SLR Ref No.: 610.30495-L02-v2.0-20260629.docx

Client Reference: 45-53 Macleay Street

**RE: 45-53 Macleay Street, Potts Point
Council and Urbis Comments Addressed**

Figure 1 Bulky waste storage areas

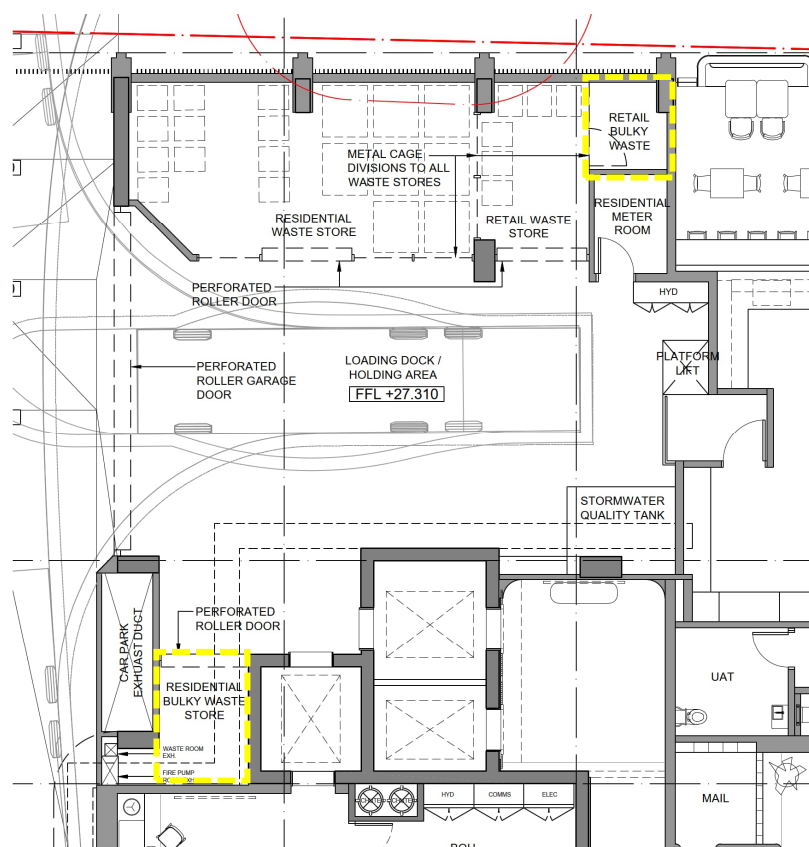
The bulky waste and problem waste storage area must be designed in accordance with Section B.2.2 of the Guidelines

Section B.2.2 requires a lockable cage, designated screened area or room in or attached to the storage area dedicated for bulky waste and problem waste.

New drawings have been prepared that show retail and residential bulky waste areas that comply with these requirements. These are shown in Figure 1 below.

Figure 2 Retail and residential waste storage areas

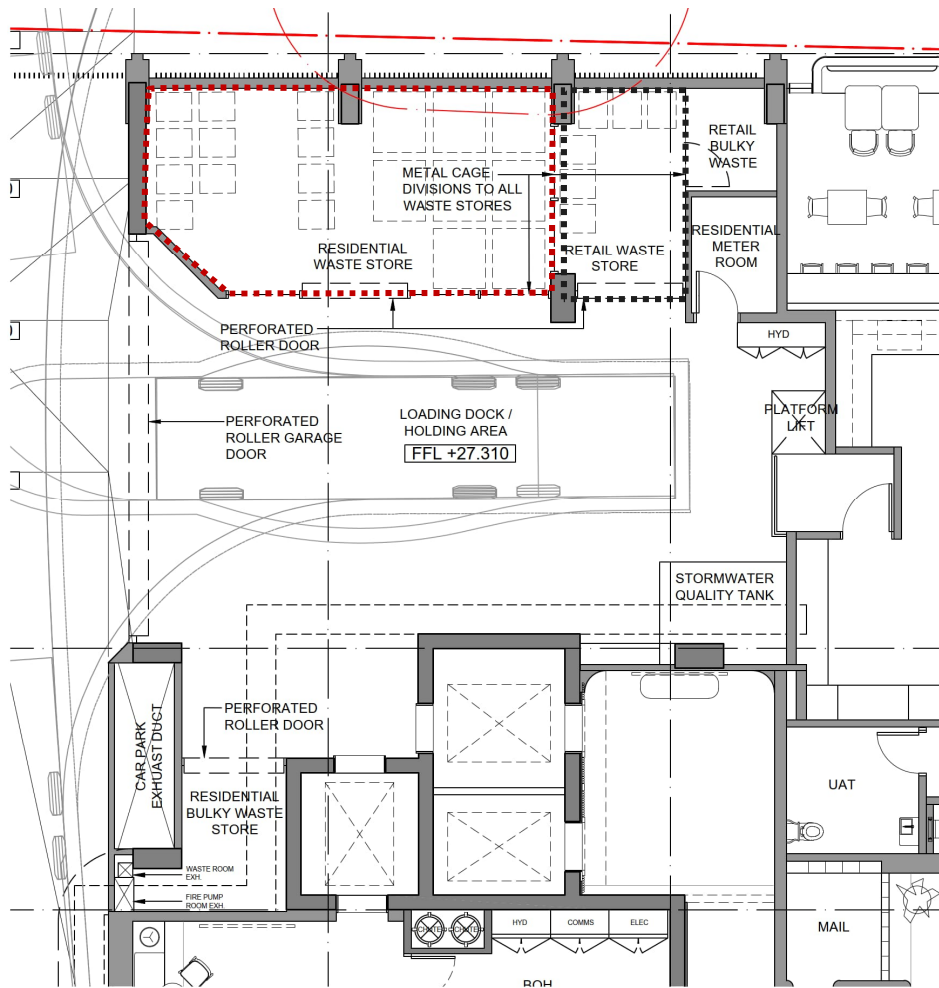
The proposed development must ensure that waste and recycling systems for the residential (residential) and non-residential (Commercial/Retail) components are entirely separate and self-contained in accordance with Section E.1.1 of the Guidelines

The design of the development has been amended to allow for separate and secured residential and retail waste storage areas. These are shown in Figure 2 below.

Figure 3 Retail access to loading dock

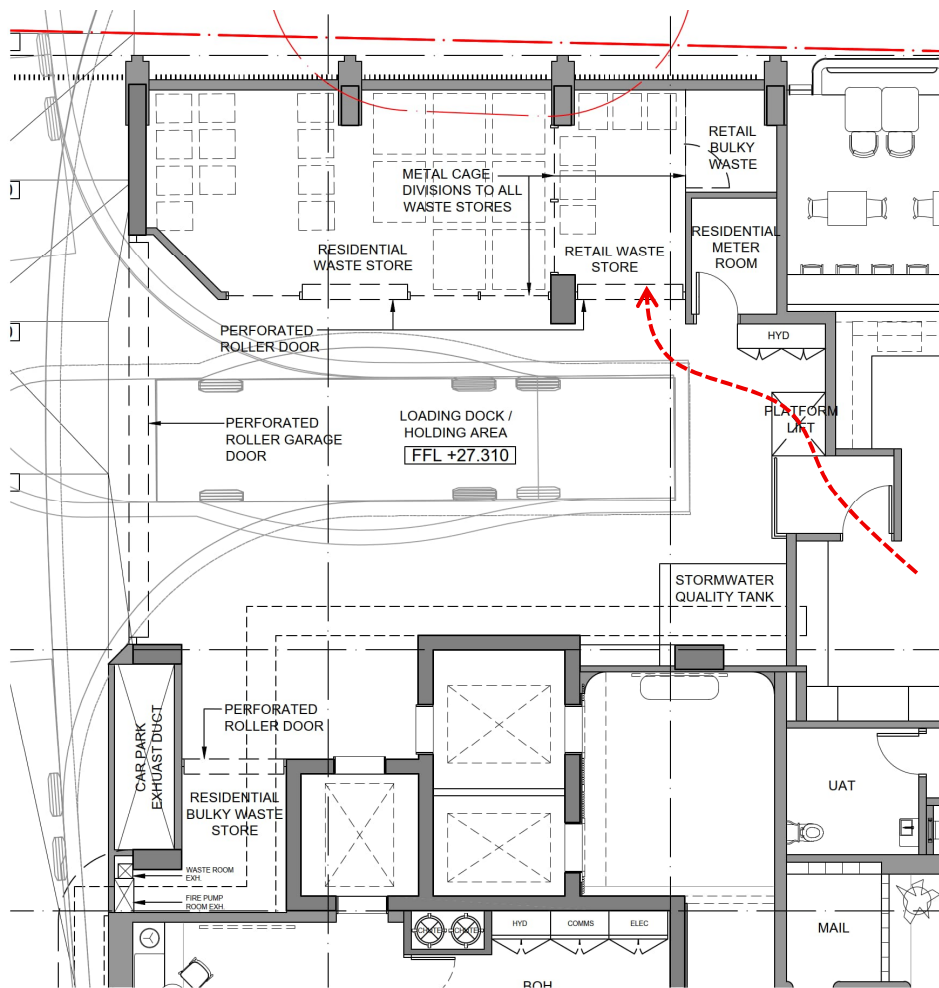
All waste transfer must be completed wholly within the development, without relying on the public domain

The design of the development has been amended to allow access to the loading dock from within the retail tenancy. No waste transfer across public areas is proposed. This is shown in Figure 3 below.

Figure 4 Dual chutes

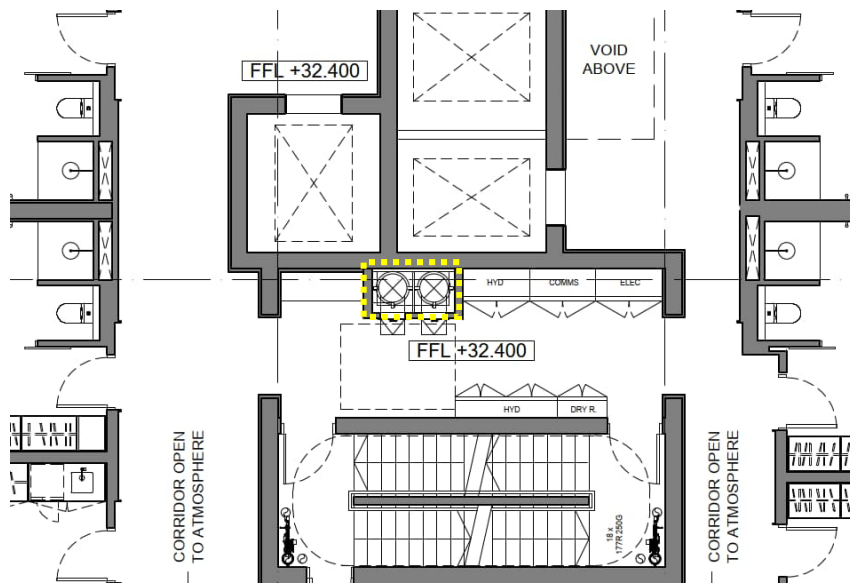
The use of a single e-diverter chute system for the residential component is not supported as it has a high contamination rate. A dual-chute system must be provided to facilitate intuitive source separation.

The design of the development has been amended to allow for two chutes to be installed, one for garbage and one for recyclables. This is shown in Figure 4 below.

Figure 5 Chute room

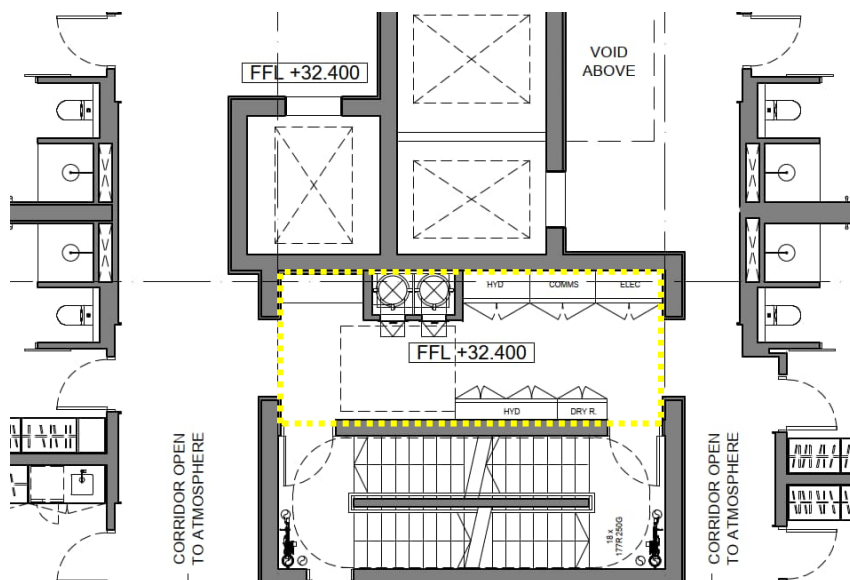
FOGO disposal points should be provided on every residential level as per Section B.4.1 as the current proposal requires residents to carry food waste to a centralised location in the basement, which exceeds the maximum allowable travel distance of 30 m from the unit entrances.

Section B 4.1 says that *A chute room is required on each habitable floor of a development that has a chute system.* The development already complies with this requirement as shown in Figure 5 below

Despite that, and with regard to the NSW Government Food Waste Mandate, a FOGO room has been provided on a basement level, and a FOGO disposal point will be provided on Levels 1 and 2. These will be serviced and managed by the building manager or affordable housing provider. The distance from the furthest residential door to the FOGO disposal point is 19 m which is well within the 30 m requirement.

Figure 4 FOGO bin on Levels 1 and 2

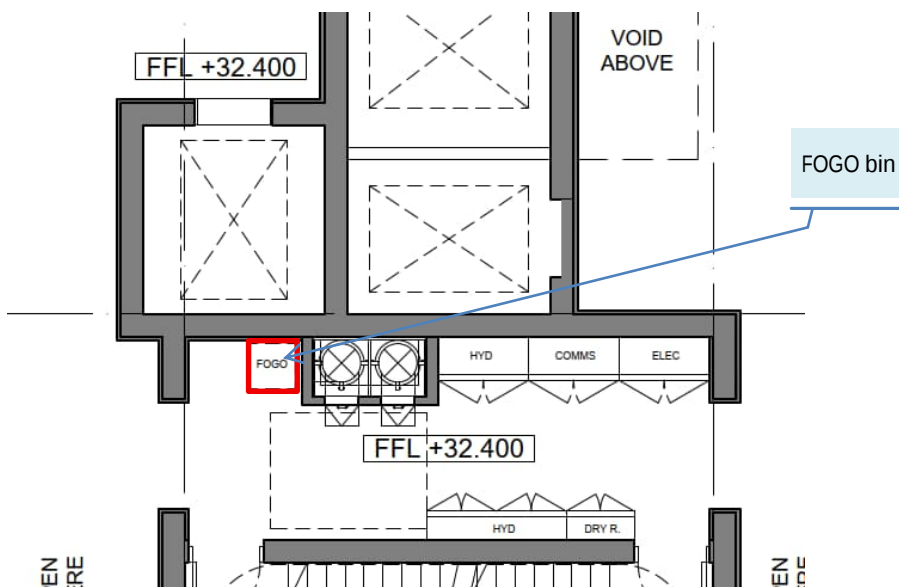
Urbis suggested that discrepancies in where FOGO disposal points are located should be clarified.

The location of the FOGO collection points is described in Section 9.4.1 Residential, which states *Residents on Levels 1 and 2 will take their food waste to a FOGO disposal point on each floor.* The location is shown in Figure 4.
